# CITY OF ALBUQUERQUE

**RE: 4th & Montano Dental Office  
Grading and Drainage Plan  
Engineers Stamp Date 7/6/15 (F14D055)**

**TIERRA WEST, LLC**

**RE: 4<sup>TH</sup> AND MONTANO DENTAL OFFICE  
GRADING AND DRAINAGE PLAN (F14-D055)**

ENGINEER'S SEAL	4TH ST AND MONTANO DENTAL OFFICE	DRAWN BY DY
		DATE 6/30/15
	GRADING AND DRAINAGE PLAN	2014099-GRE
	RONALD R. BOHANNAN P.E. #7868	 TIERRA WEST, LLC 5571 MIDWAY PARK PLACE NE ALBUQUERQUE, NM 87109 (505) 858-3100 www.tierrawestllc.com
		JOB # 2014099

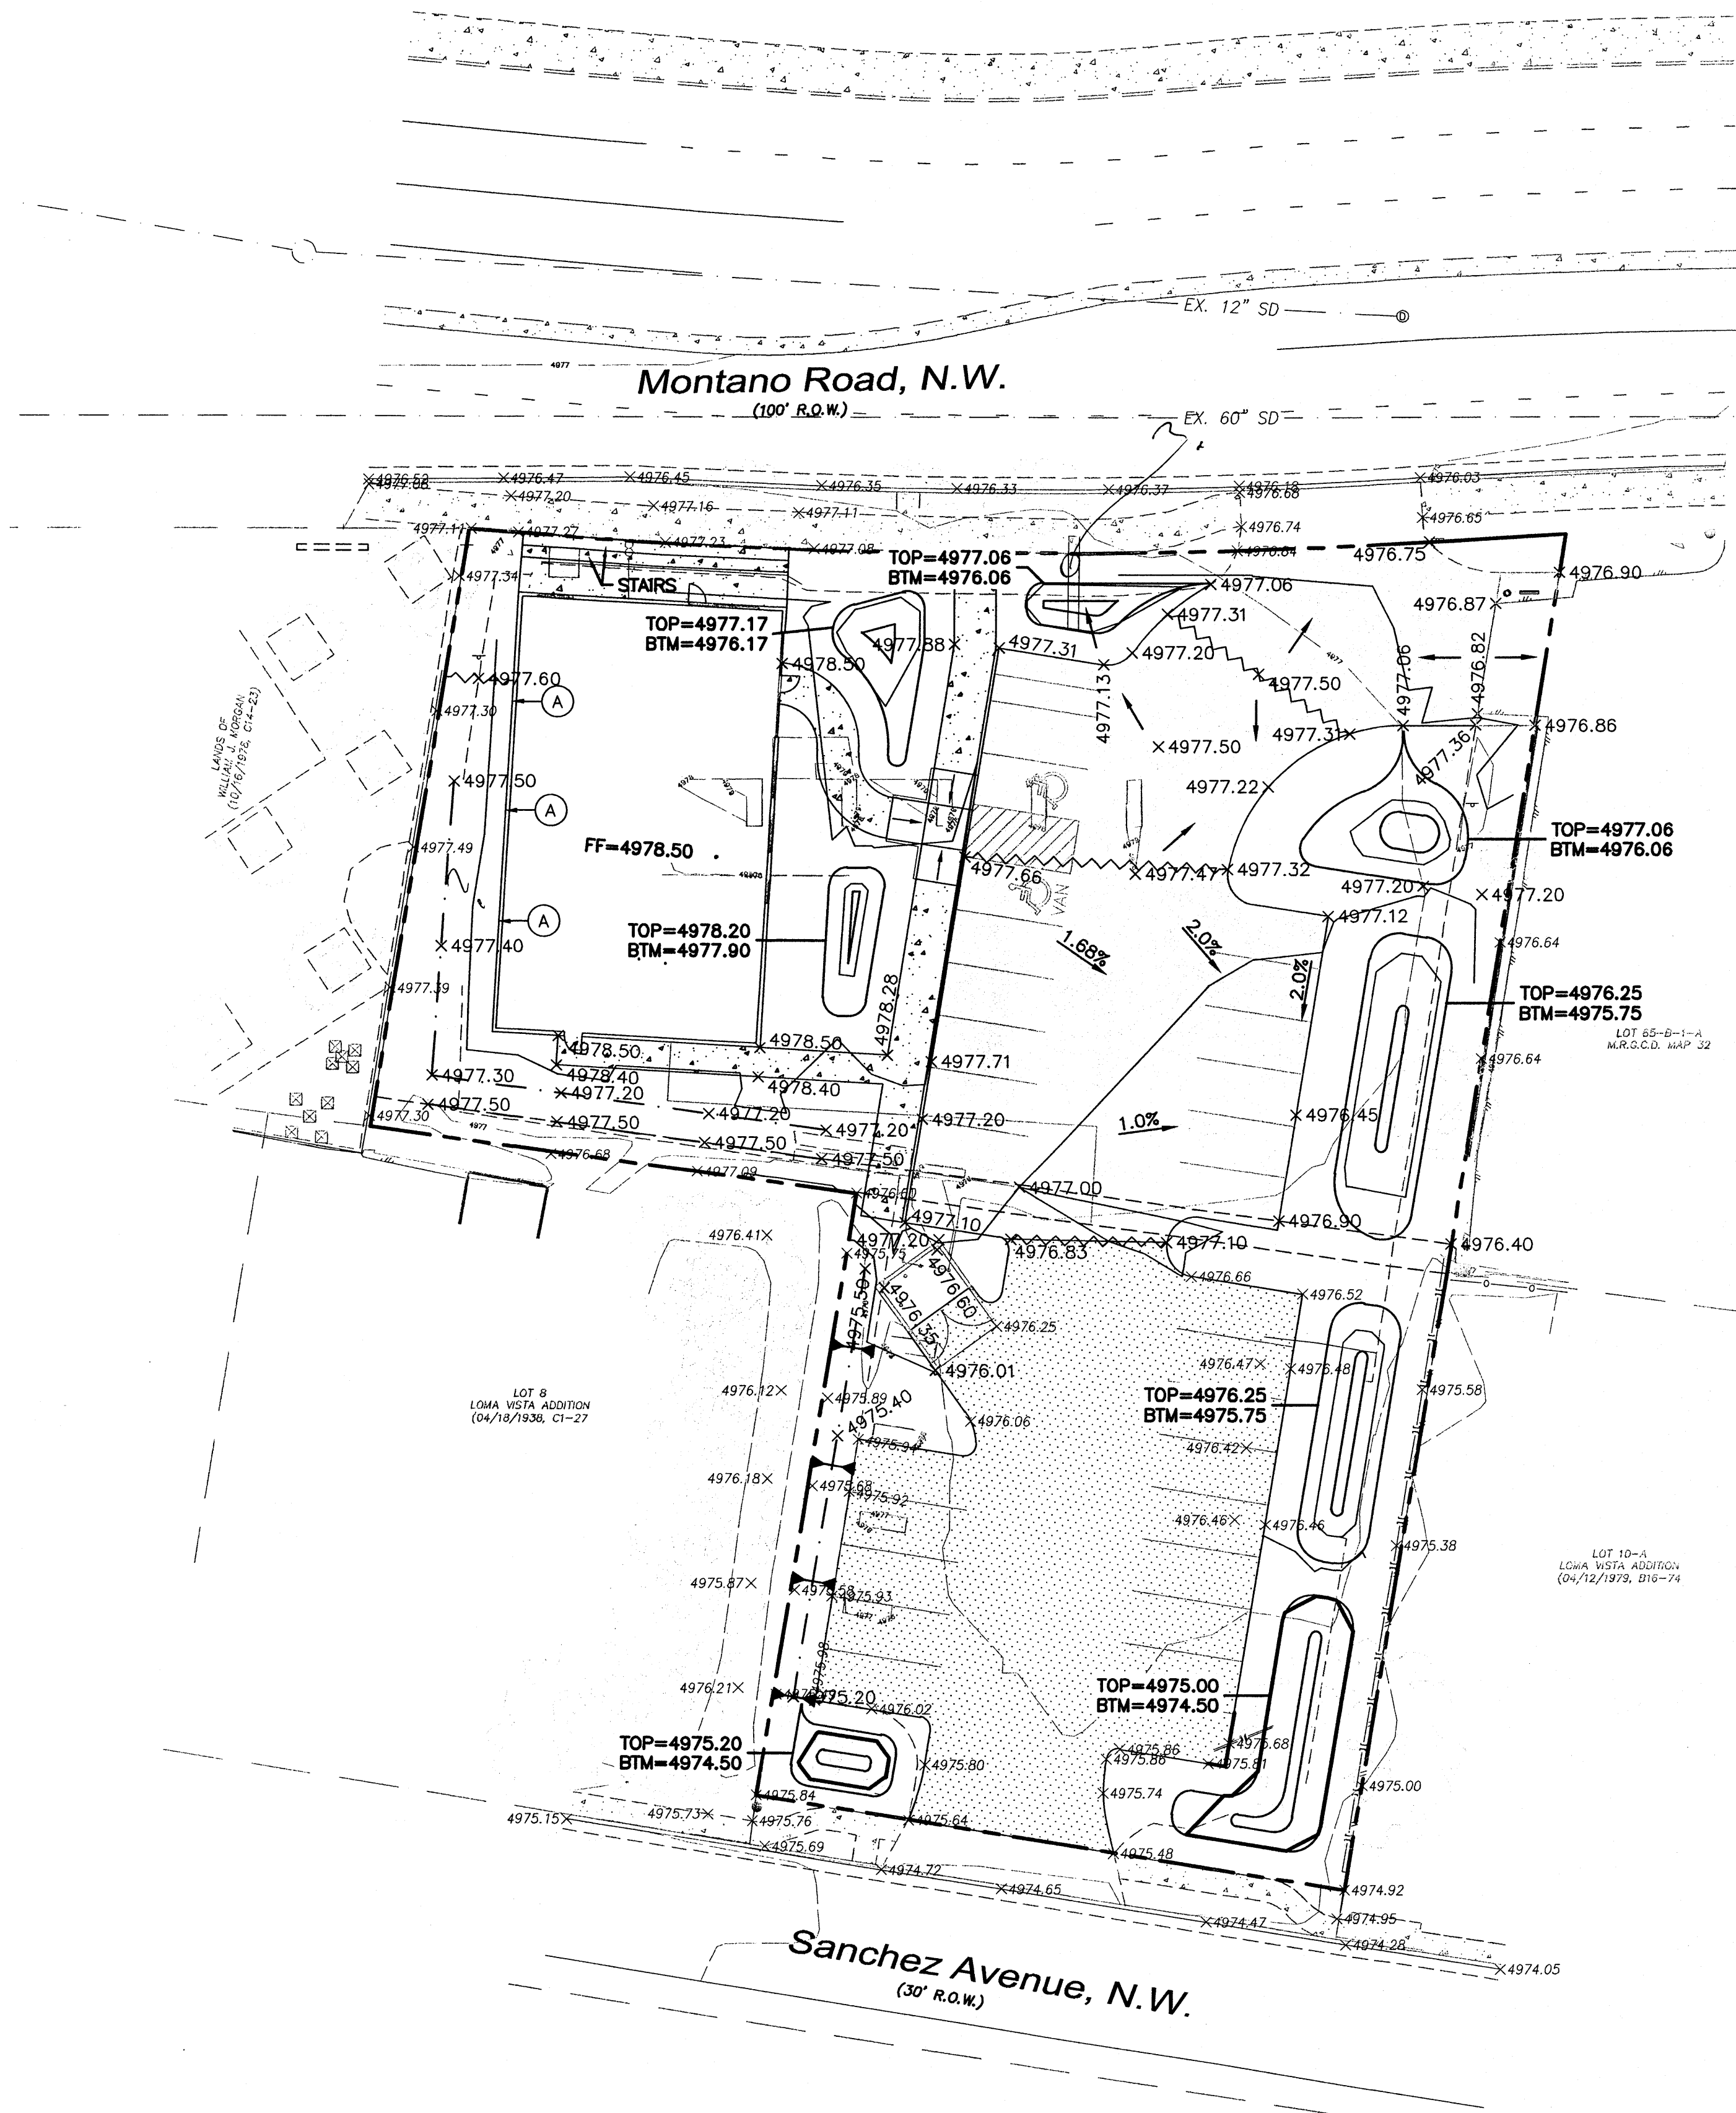
1. Are the west and south areas of the building landscaped?  
**Response: Yes they are landscaped.**
2. A cross lot drainage agreement is needed from the owners to the south.

3. Is curbing in place at the existing south parking area? If so, curb cuts will be needed.  
**Response: No. curbing is not in place in the existing south parking area.**

4. How are flows from the roof directed away from the building?  
**Response: Flows from the roof are directed to 3 down spouts on the west side of the building. These are indicated on the grading plan along with splash blocks. The runoff is captured in the drainage swale that runs along the west side of the building.**

5. What is the double line in the north landscaped area? Is this a sidewalk culvert?  
**Response: The double lines are existing contour lines. The sidewalk and concrete area along the north side of the building have been revised per comments from Planning to include a ramp and stair connection to the existing Montano Blvd sidewalk. The remaining area on the north side is now to be landscaped.**

**Response: Per discussion with Mr. Rael, additional information was added to the plan to show that a cross lot drainage agreement is not necessary as the drainage is maintained onsite.**
